April 17, 2026

TBTE Ref No: 25-520

Subject: City of Ottawa File Number: D02-02-24-0029
Update to Environmental Site Assessment Reports
Concept Plan (April 2026) – 2095 Dilworth Road
Ottawa, Ontario

MA\2023\123081\CAD_Existing\123081-CP1.dwg, CP, Oct 31, 2025 - 4:14pm, wsloss

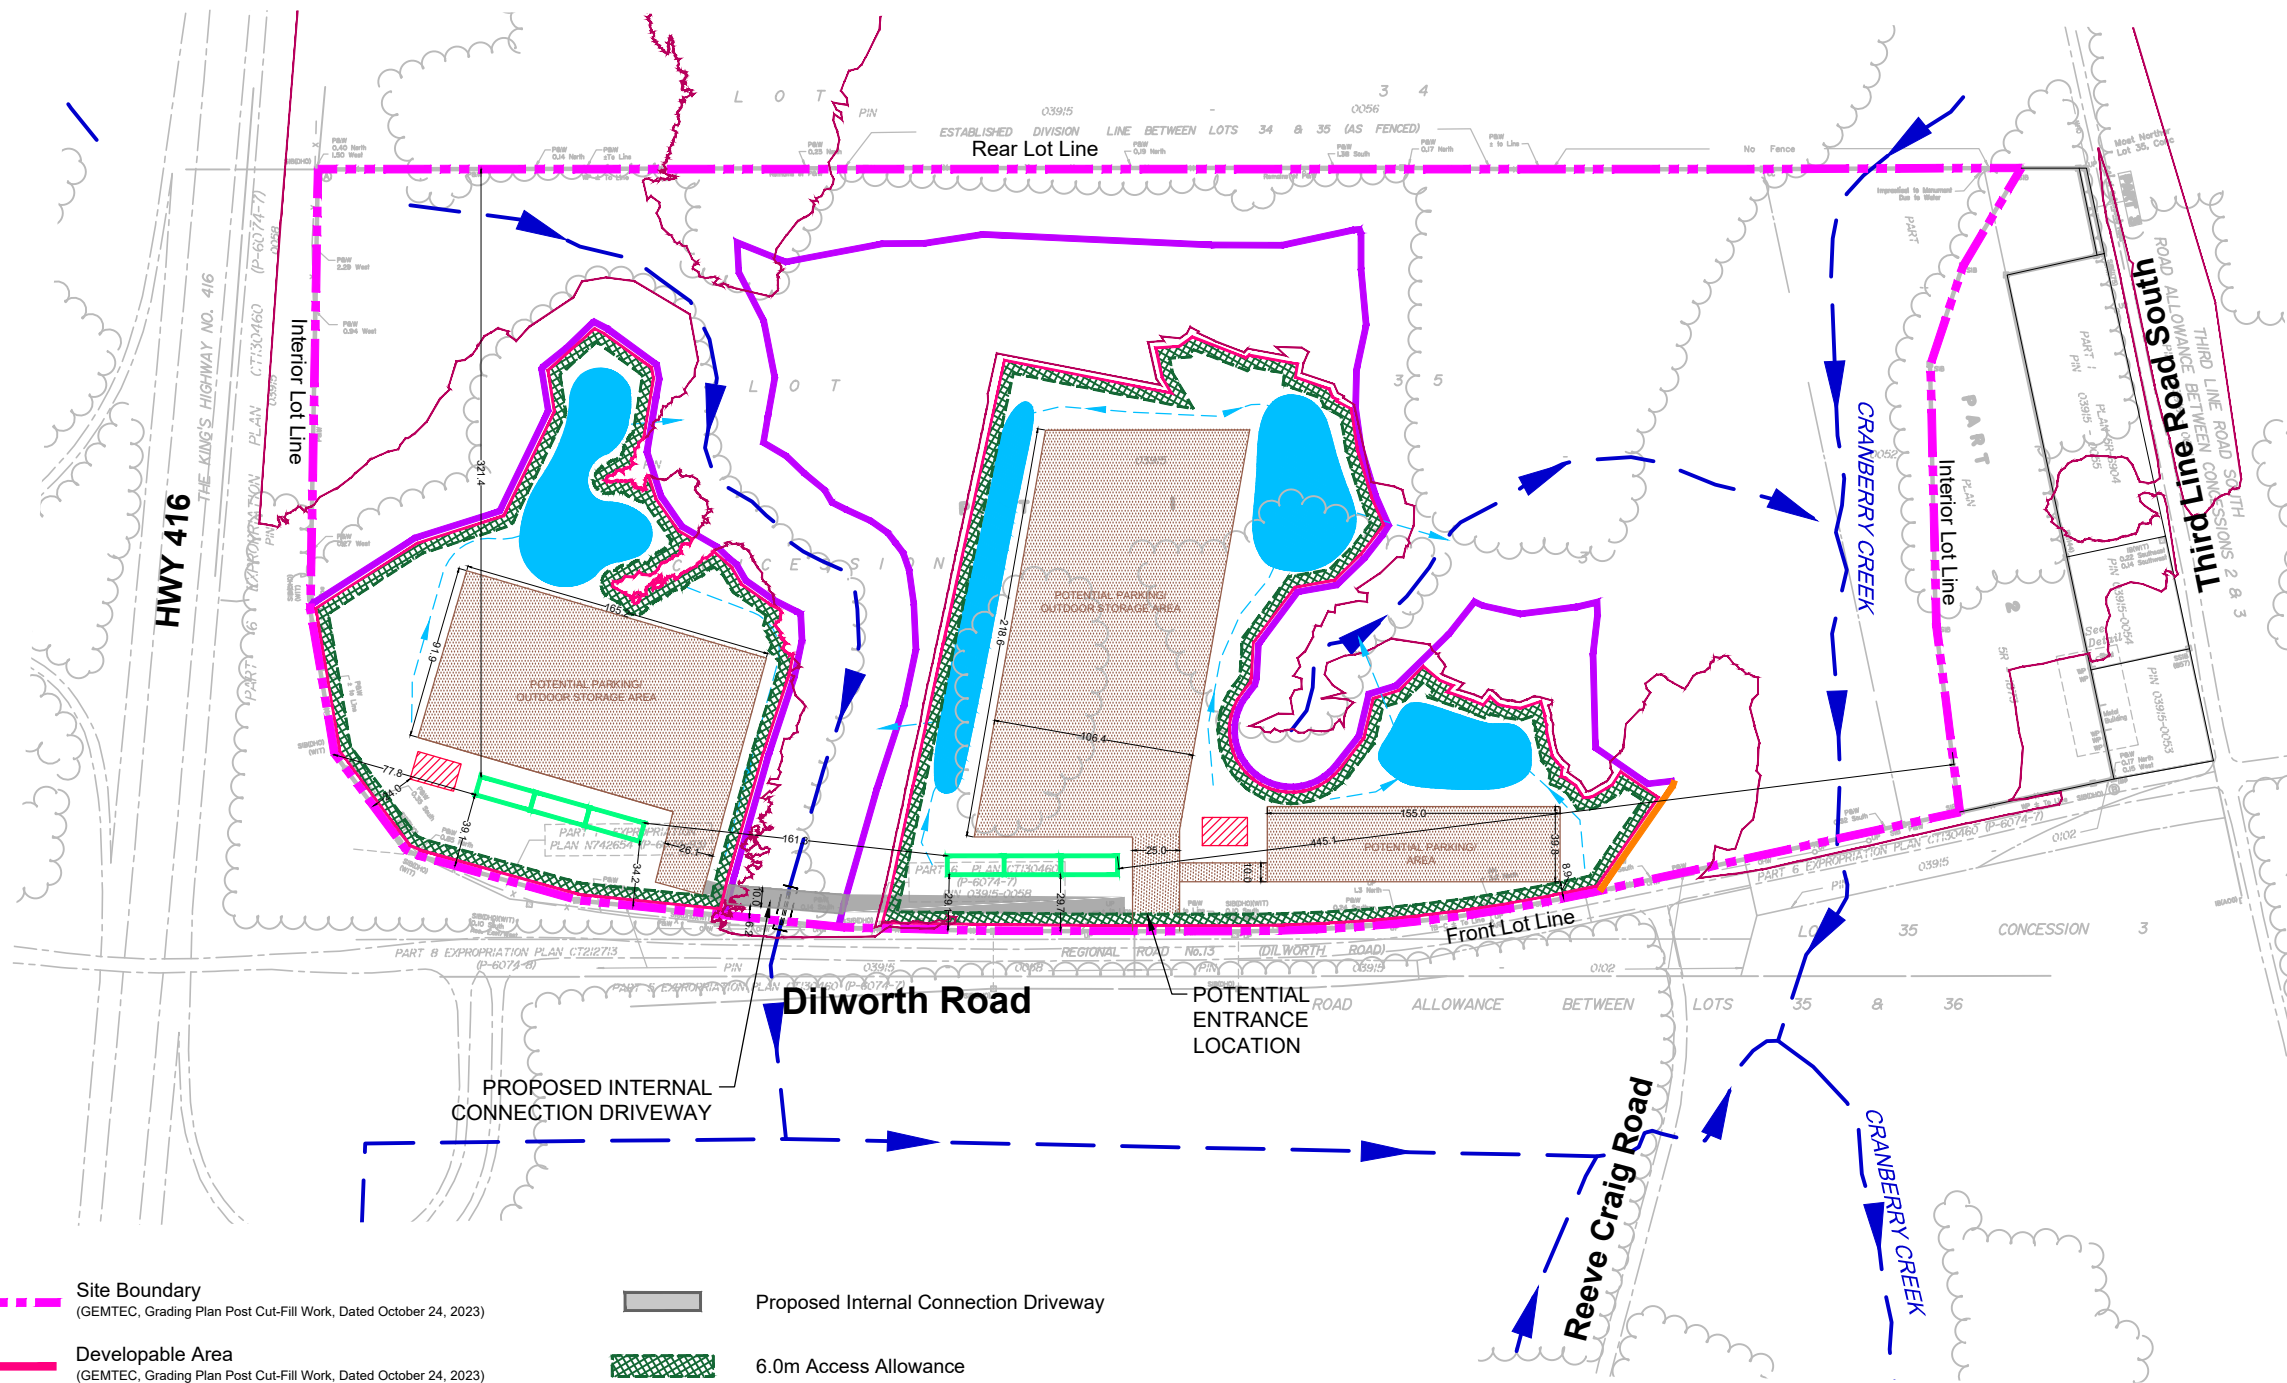
City of Ottawa Comment 52: *The Concept Plan indicates that the proposed zone boundaries are based on a 30m setback from non-PSWs and a 50m setback from PSWs. Revise the Plan.*

The current potential concept plan prepared by the Planner is included in Attachment A of this letter.
